Our Ref: R/2019/17/B and R/2017/22/F
File No: SSD 10376 and SSD 8876

RTS - Pitt Street South Over Station Development Stage 2 – SSD 10376 (Detailed Design) and SSD 8876 Mod 2 (Concept DA).

The following comments are provided by the City of Sydney (the City) for your consideration and are in response to the written submission and the meeting on 24 September 2020:

**Figure 4** Location of EOT facilities for retail workers on Level 2

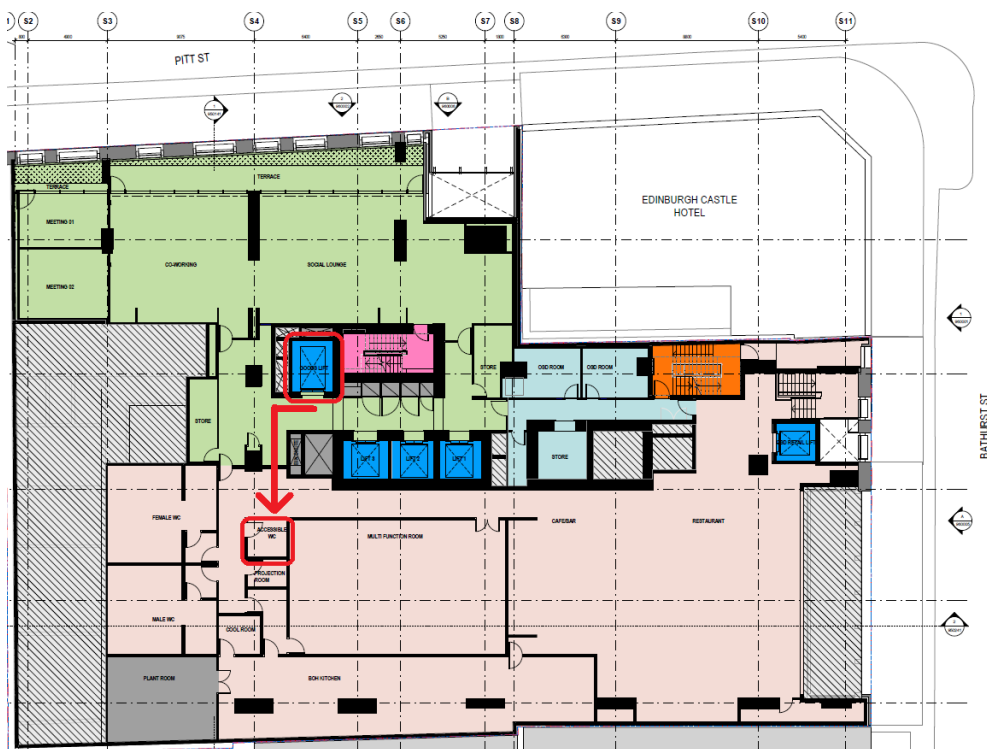
The applicant notes there is a shortfall of bike parking noting that 203 bike parking spaces are provided including 12 on the retail level. These do not seem to be indicated on the plan for Level 2 and it is not clear how these are accessed or if they have any end-of-trip facilities.
